Rezoning Transportation Analysis

Petition Number: #2022-052

General Location Identifier: 05911329

Date	Description
08-24-2022	First Review (KP)
09-22-2022	Second Review (KP)

SHEET NO.
RZ-1

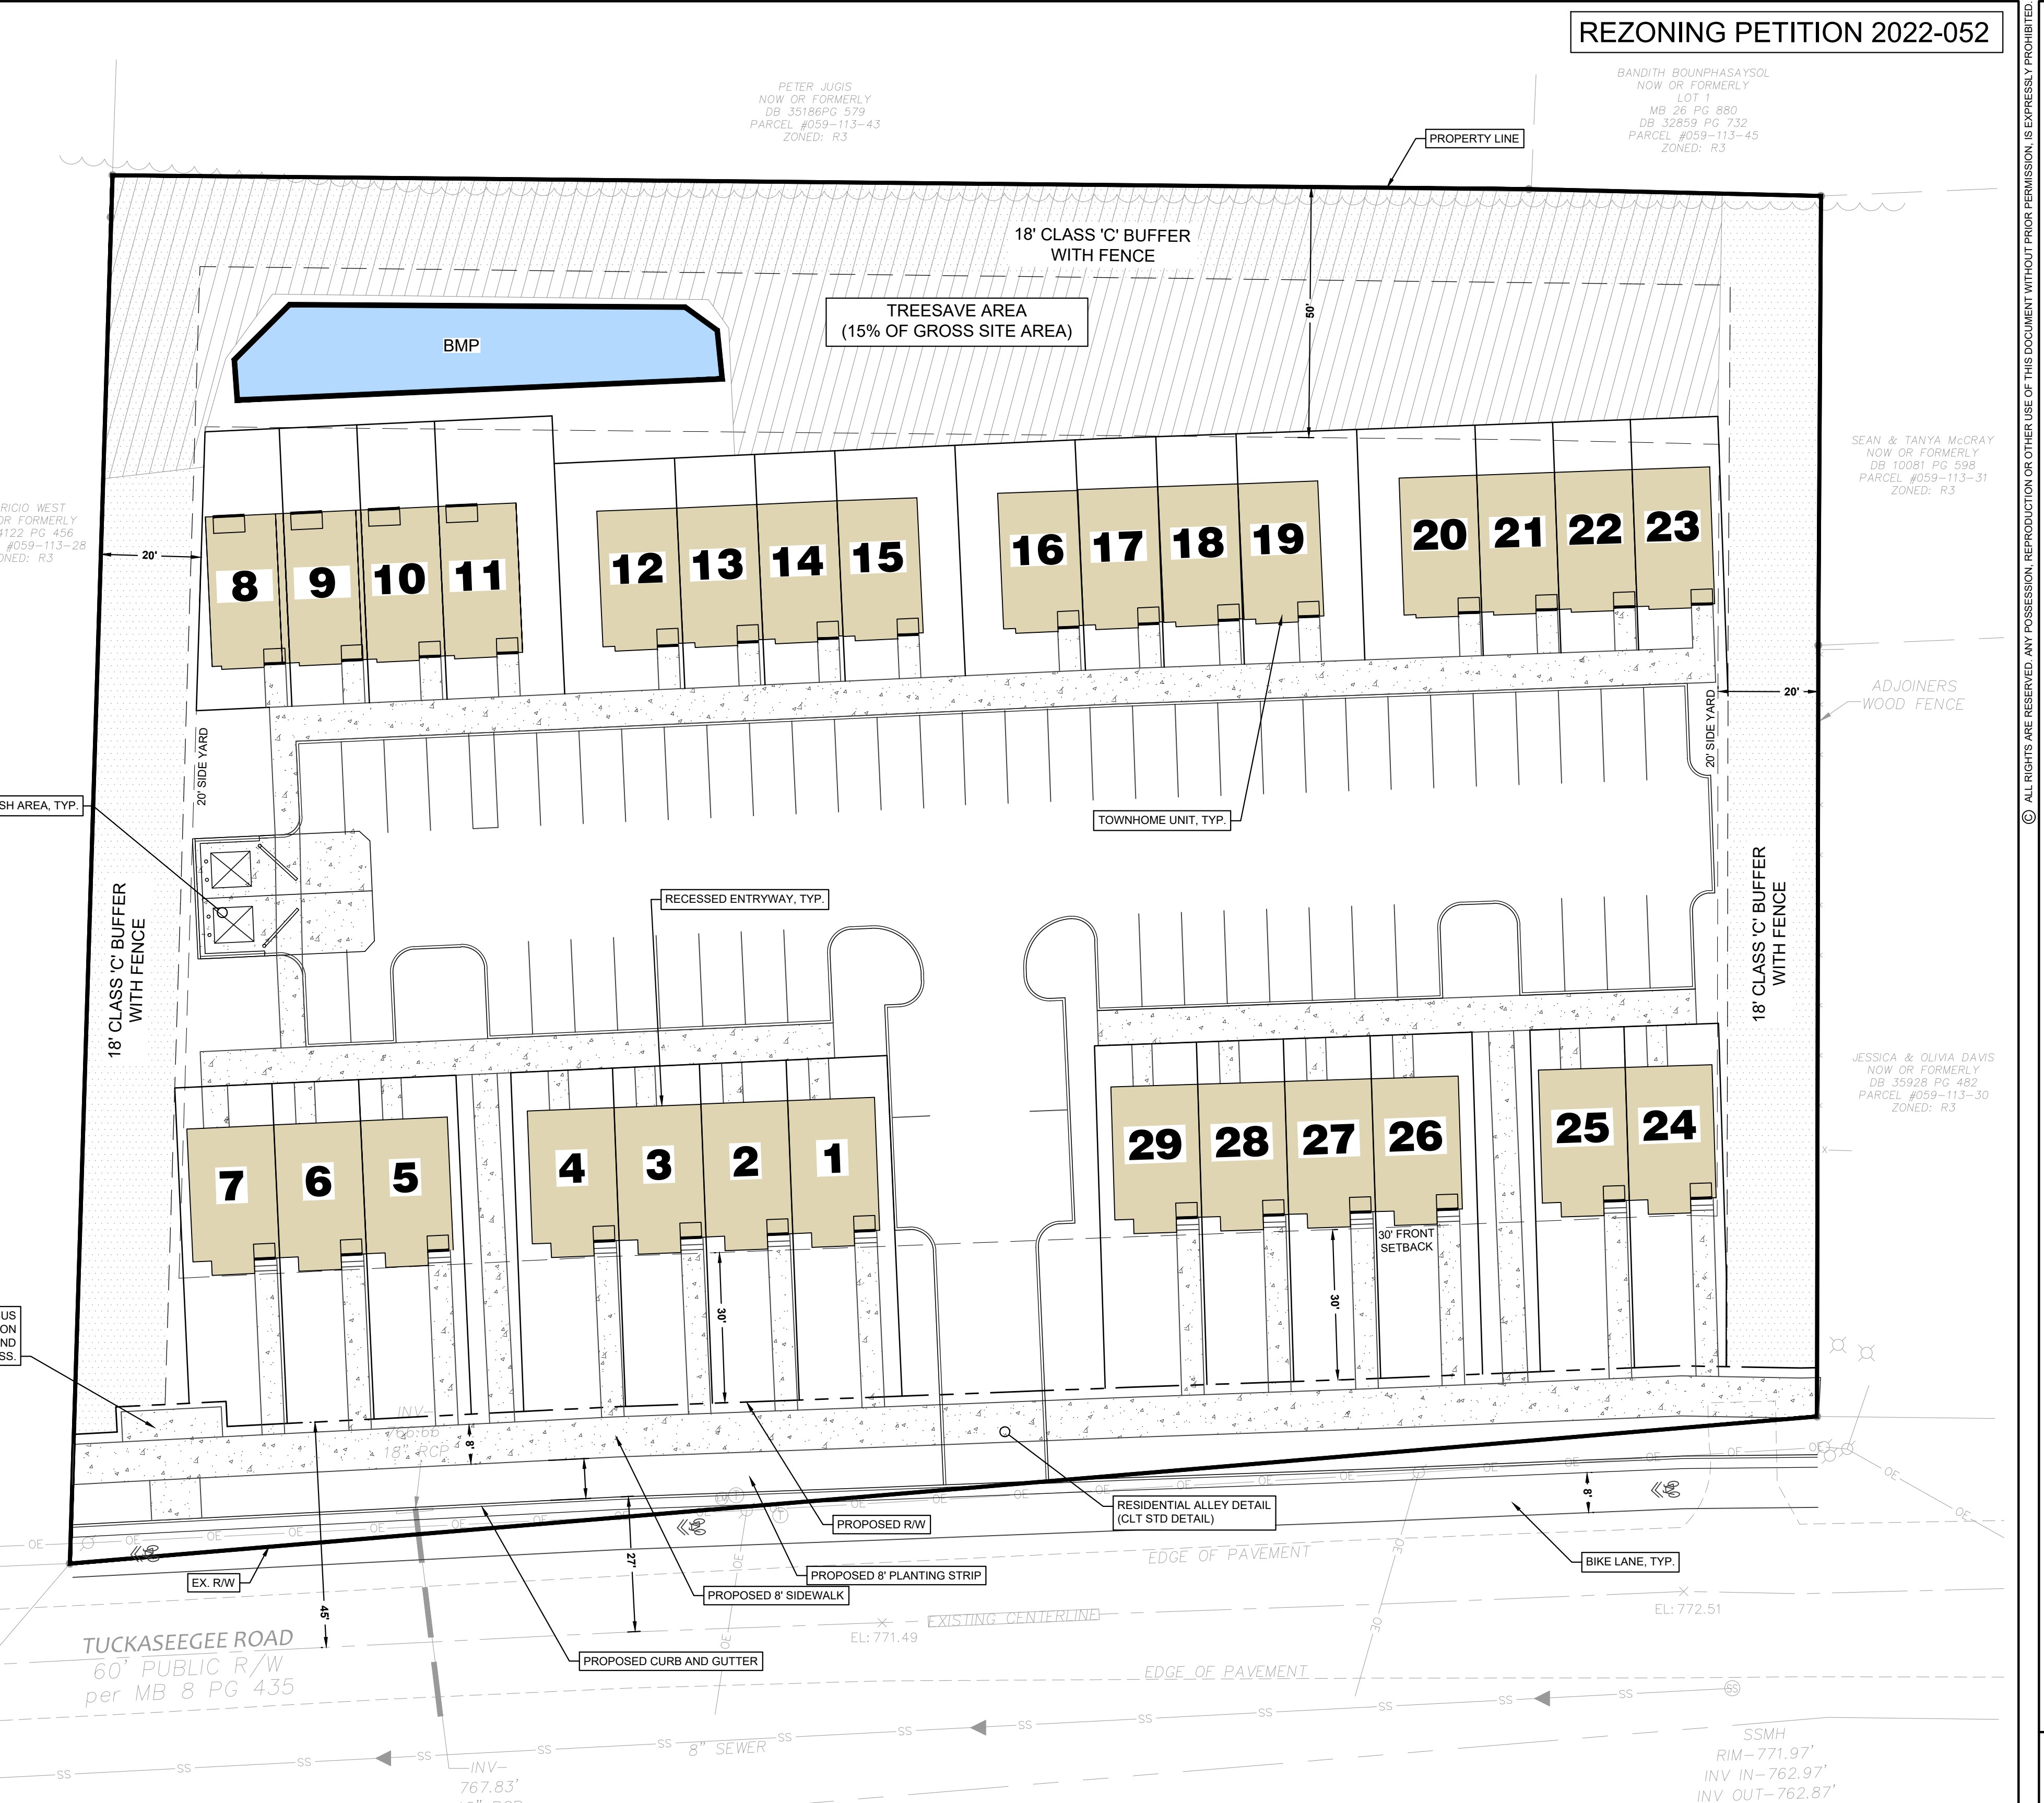
- Outstanding from 08-24-2022:** Revise the site plan and conditional notes by committing to construct curb and gutter, along the site's frontage of Tuckaseegee Road, measured 27-feet from the existing centerline to back of curb.

Label and dimension the back of curb from the existing centerline of Tuckaseegee Road. **Comment update:** Clearly label proposed curb and gutter.

- Outstanding from 08-24-2022:** Revise site plan and conditional note(s) to commit to dedicate 45-feet of right-of-way along the site's frontage of Tuckaseegee Road.

The site plan shall label and dimension the right-of-way from the road centerline. **Comment update:** Clearly label proposed right-of-way element.

- Outstanding from 08-24-2022:** Revise site plan and conditional note(s) to commit to construct an 8-foot planting strip, and 8-foot sidewalk along the site's frontage of Tuckaseegee Road. The site plan shall label and dimension both items from the back of curb and gutter. **Comment update:** Clearly label proposed planting strip and sidewalk elements.
